# CITY OF ALBUQUERQUE

August 29, 2023

RE: **Lot 21 Block 6 Volcano Cliffs Unit 18  
6604 Papagayo Rd NW SAD 228  
Grading and Drainage Plan  
Engineers Stamp Date 5/23/2023 (D10D003J5)  
Pad Certification Date 8/24/2023**

SHEET NO:
C-1

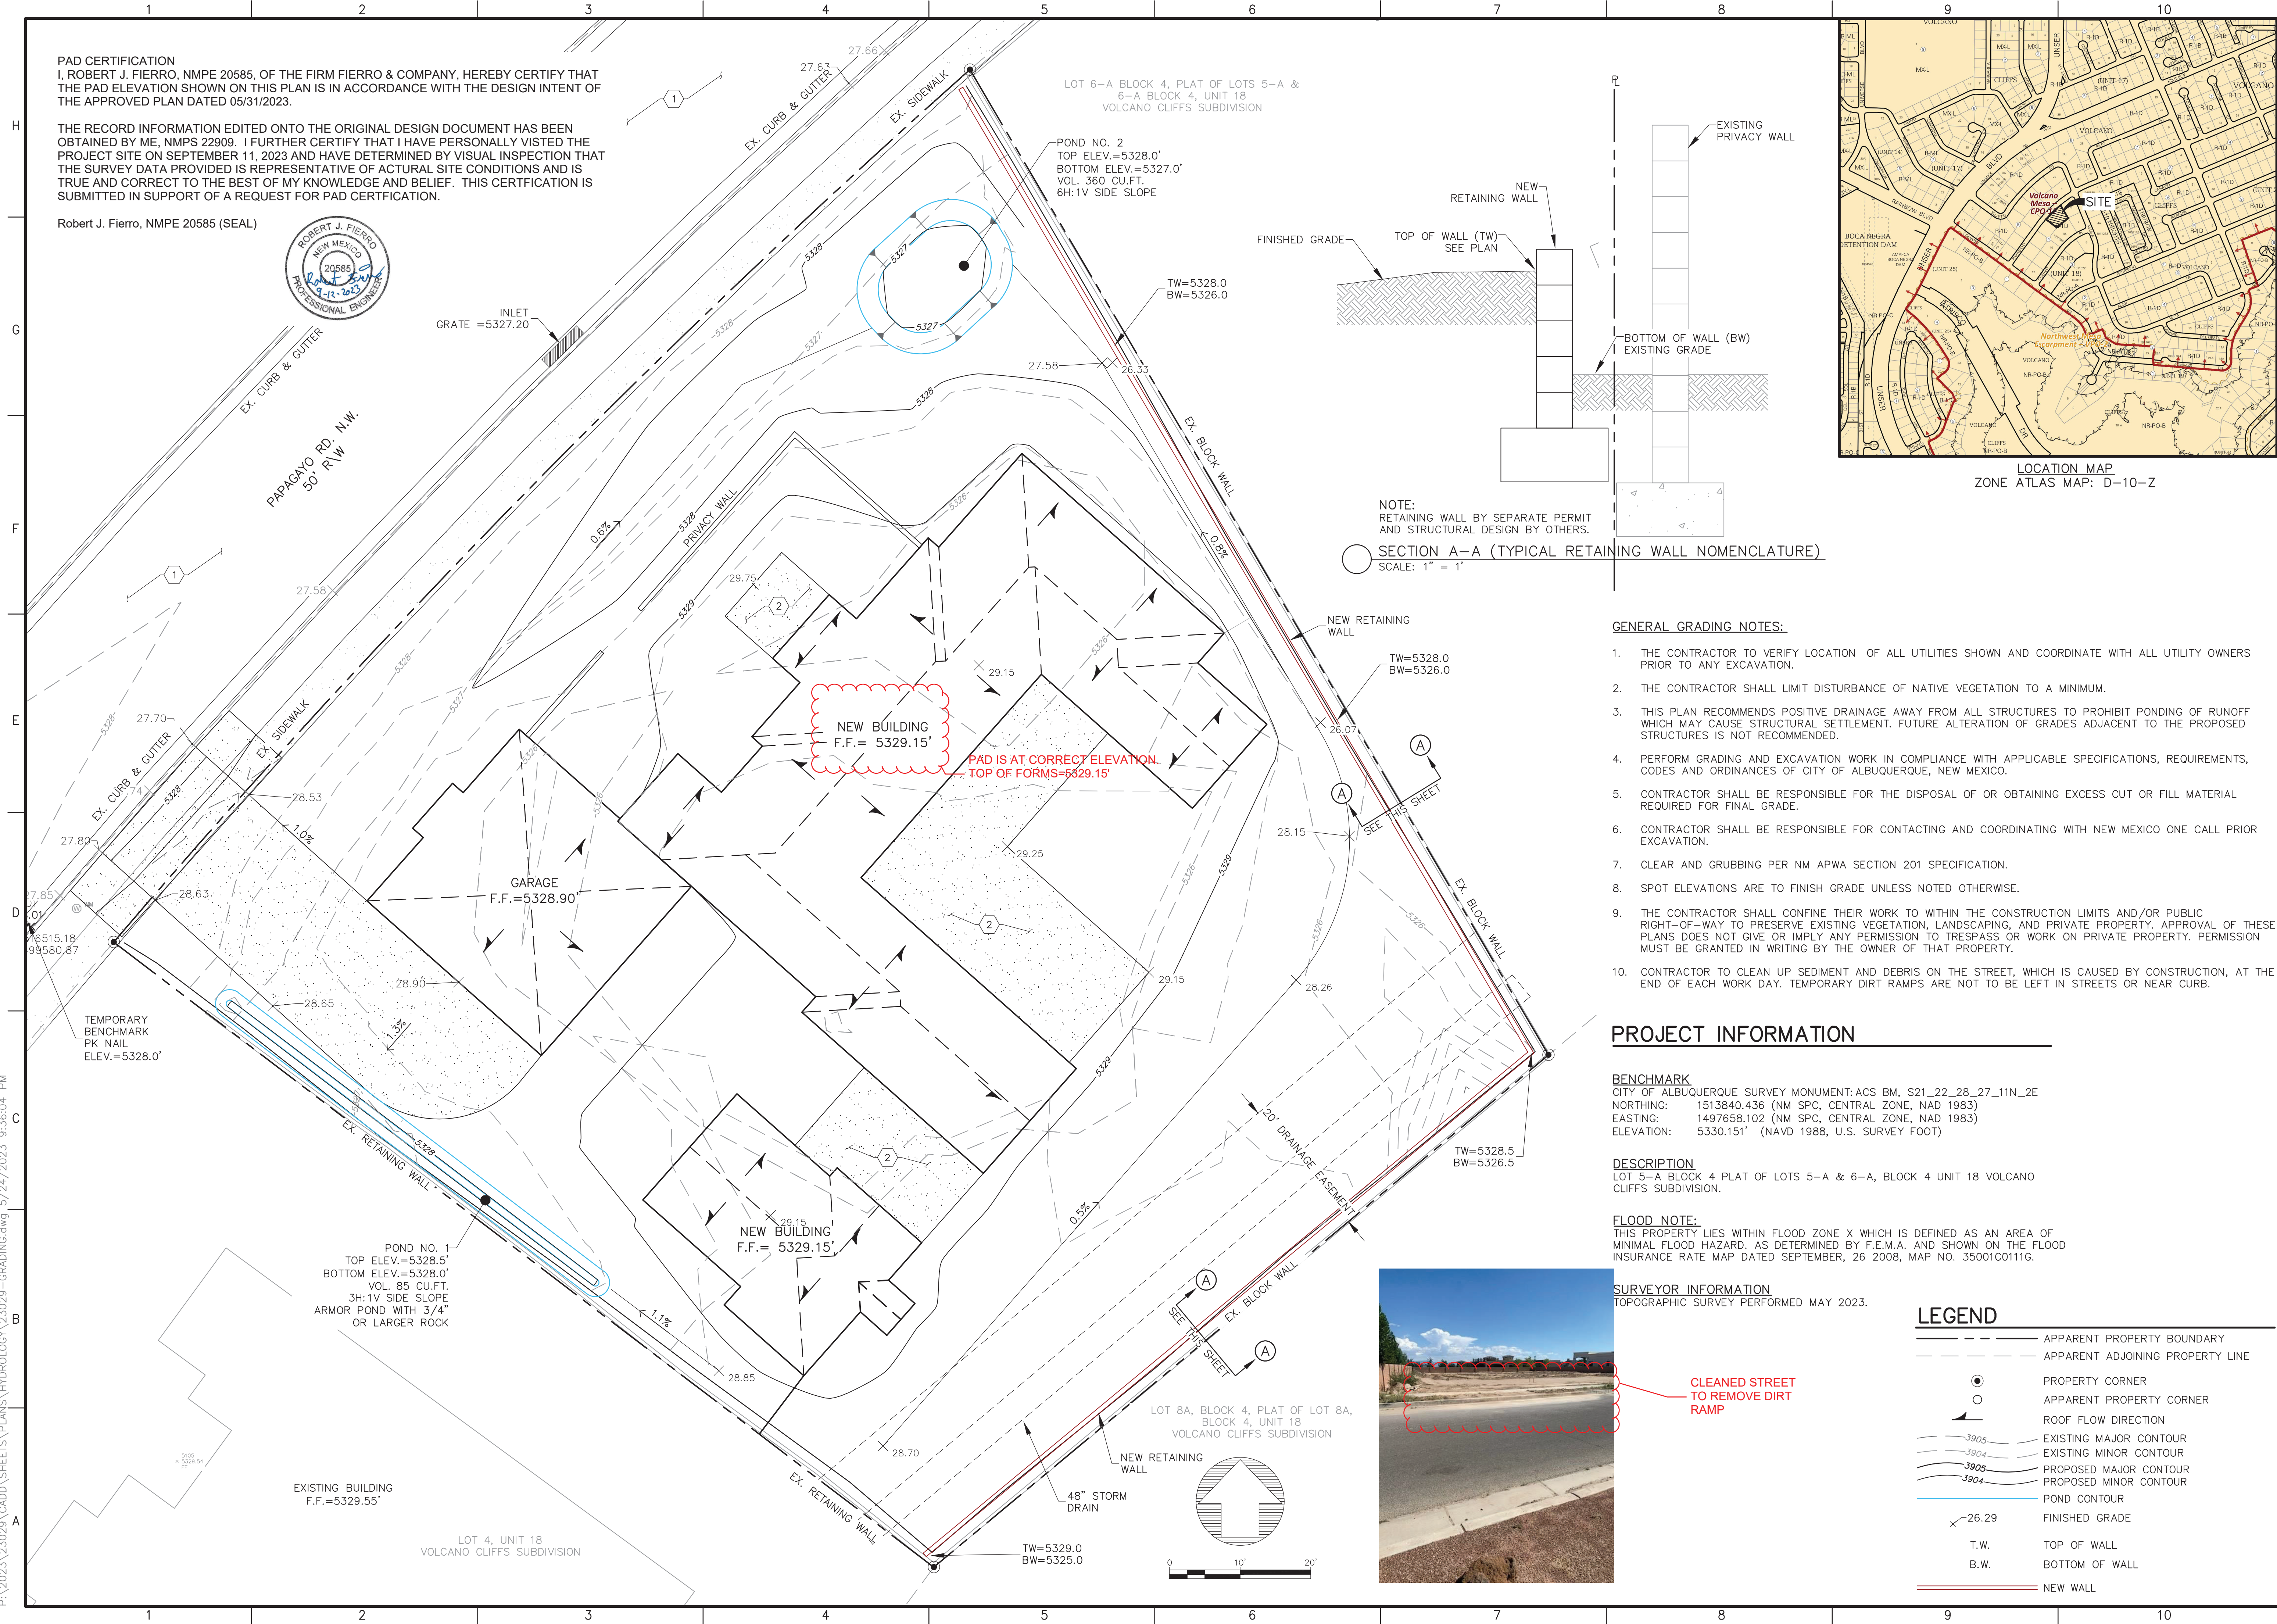
- The dirt ramp in the street and sidewalk must be removed and swept so as not to fill the pond for this area.

**Once again, advise the owner contractor not to use dirt as a ramp to climb the curb, use lumber or crusher fines for this purpose.**

Reiterate to the Owner/Contractor that a separate permit for a garden/retaining wall must be obtained with the approved G&D plan and Pad Certification. Also, if a swimming pool is to be placed, the grading and drainage plan will need to be changed and resubmitted.
